Our Ref: P/117/09/

20th January 2010

Outline application for proposed demolition of existing sub-standard bungalow for
erection of 2no. two bedroom bungalow with associated driveways
Springfield Nyetimber Lane Pagham Bognor Regis

outline planning permission with all matters reserved for demolition of sub standard bungalow for erection of two-2 bedroom bungalows with associated access driveways. Springfield, nyewood lane, pagham, west sussex.

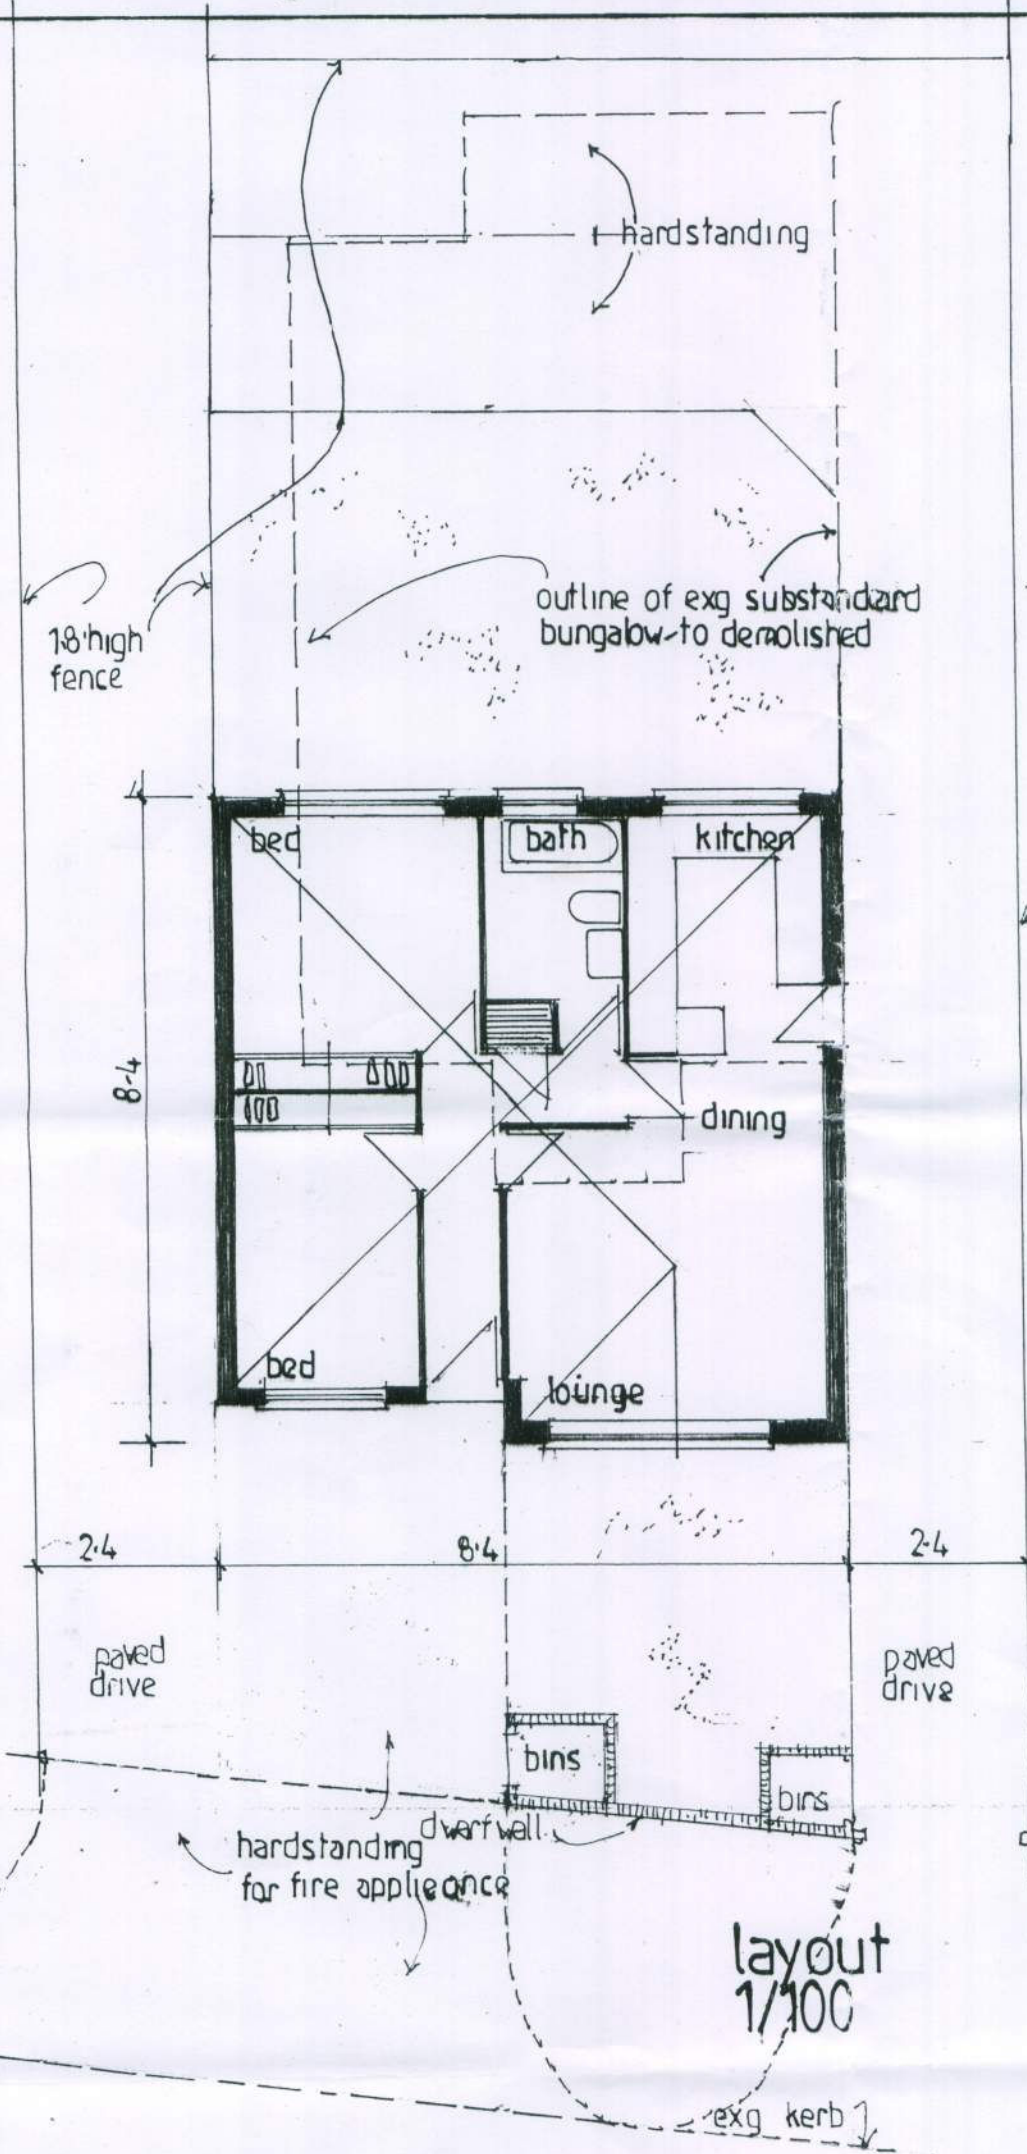
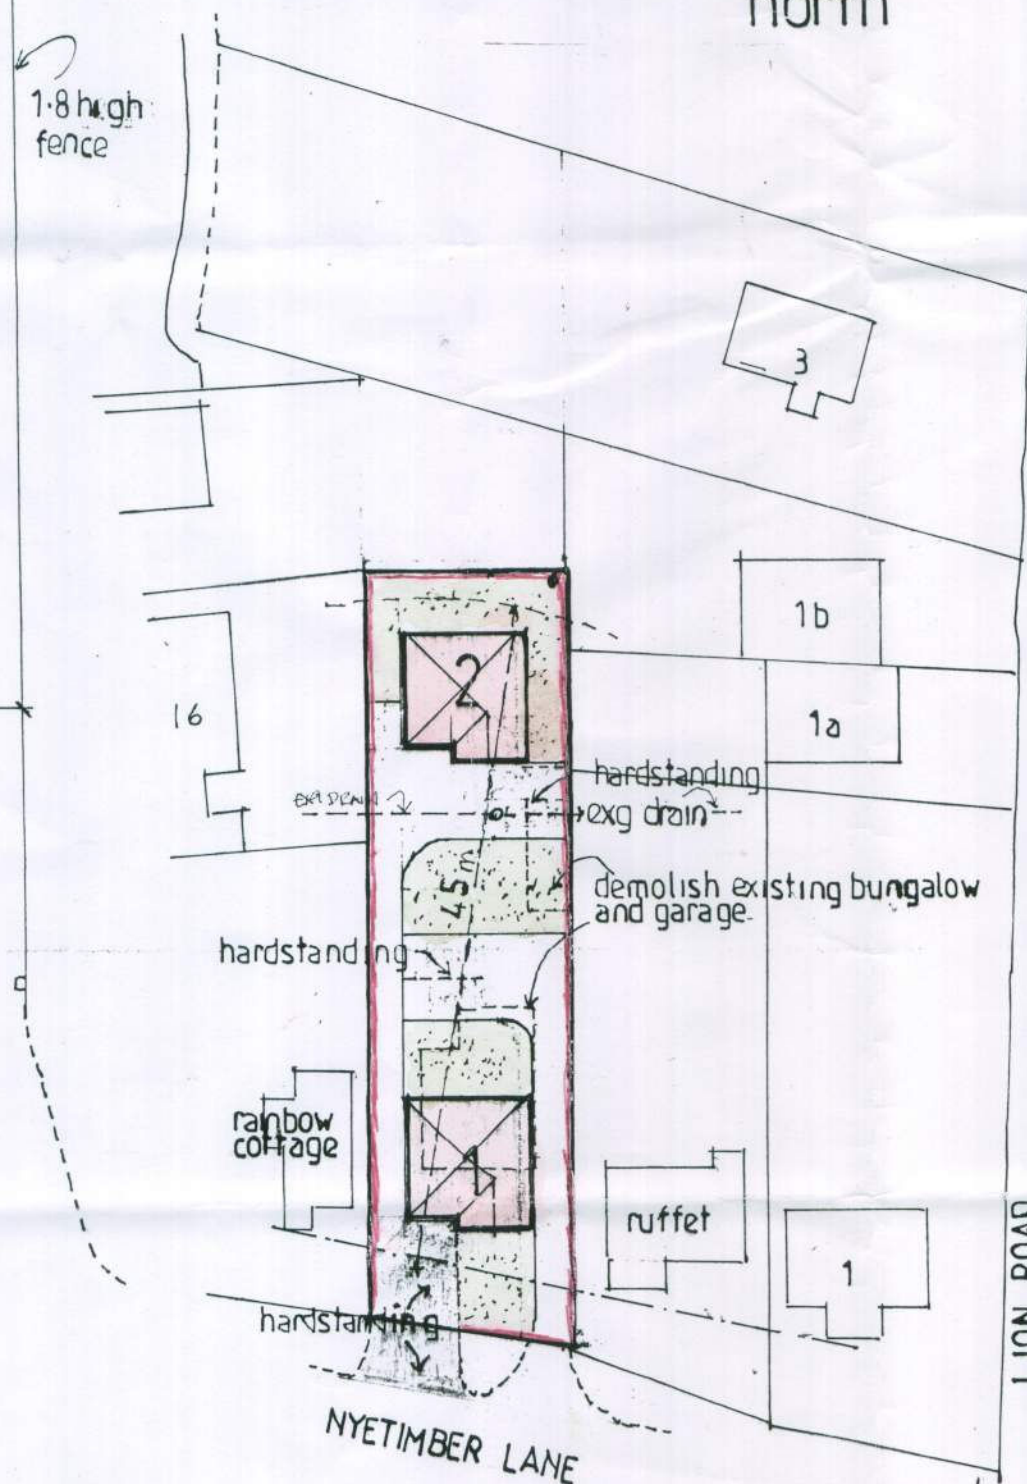
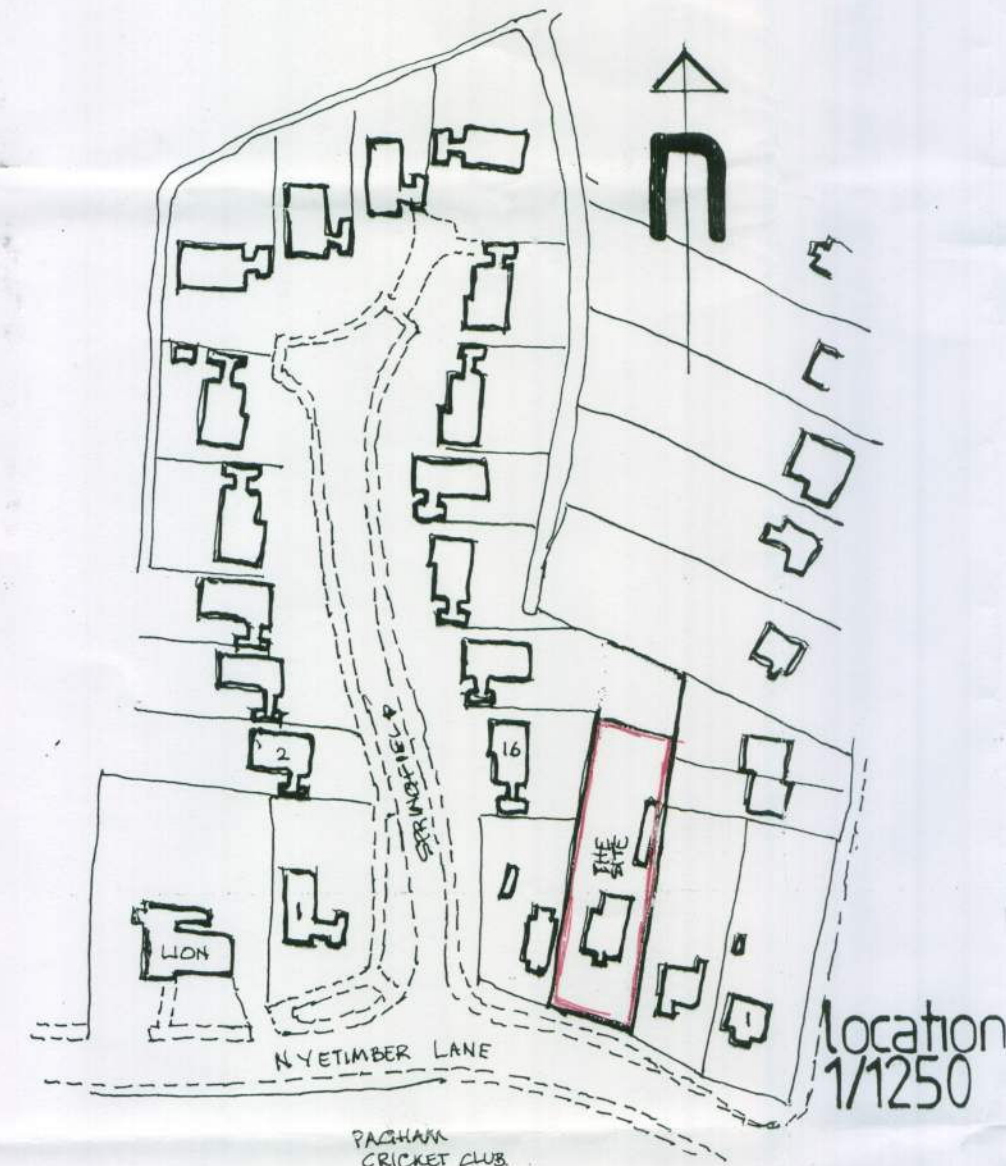
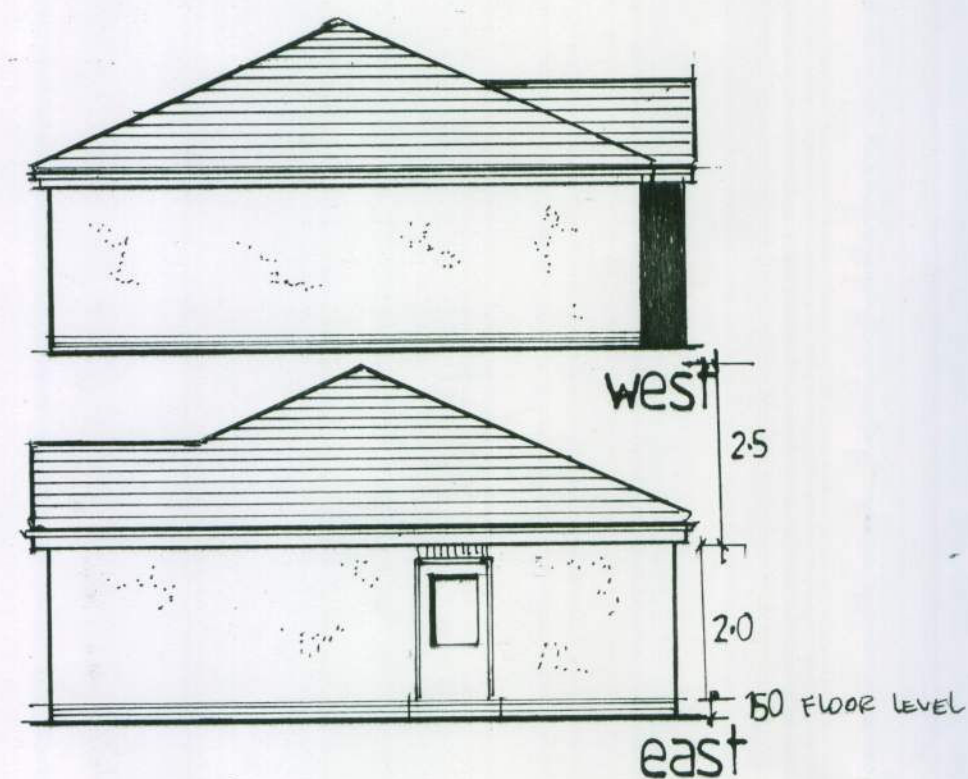
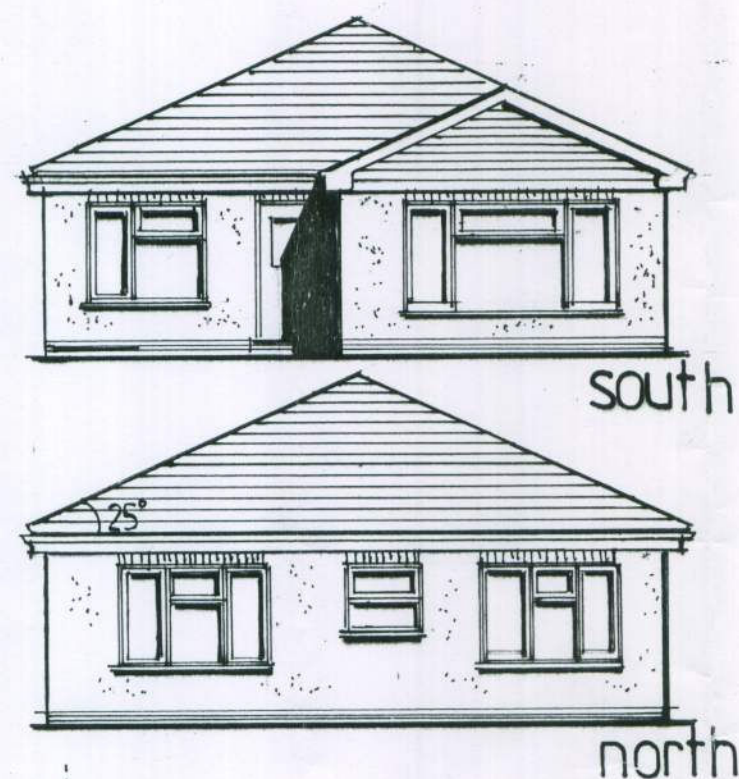
Members felt that this application was contrary to Arun District Local Policy GEN7 (ii) and the Pagham Village Design Statement development criteria for this area (Page 19) 'avoid cramped, un-neighbourly proximity' and 'exercise care to prevent loss of privacy by virtue of comparatively high density development'. □

The description of this application is incorrect, the application is in fact for two 2 bedroom bungalows not one 2 bedroom as indicated in the advertised description. This error has been pointed out to the case manager. It is assumed that this application will need to be re advertised. Upon examination of the supporting papers the following errors were identified: In the first paragraph of the Design and Access Statement it refers to the demolition of a three bedroom bungalow, In the second paragraph it describes 'Springfield' as a sub standard two bedroom bungalow. It gives the address incorrectly as Nyewood Lane. The accompanying plan in its heading similarly gives the address as Nyewood Lane although the plan itself correctly shows the property fronting onto Nyetimber Lane. □
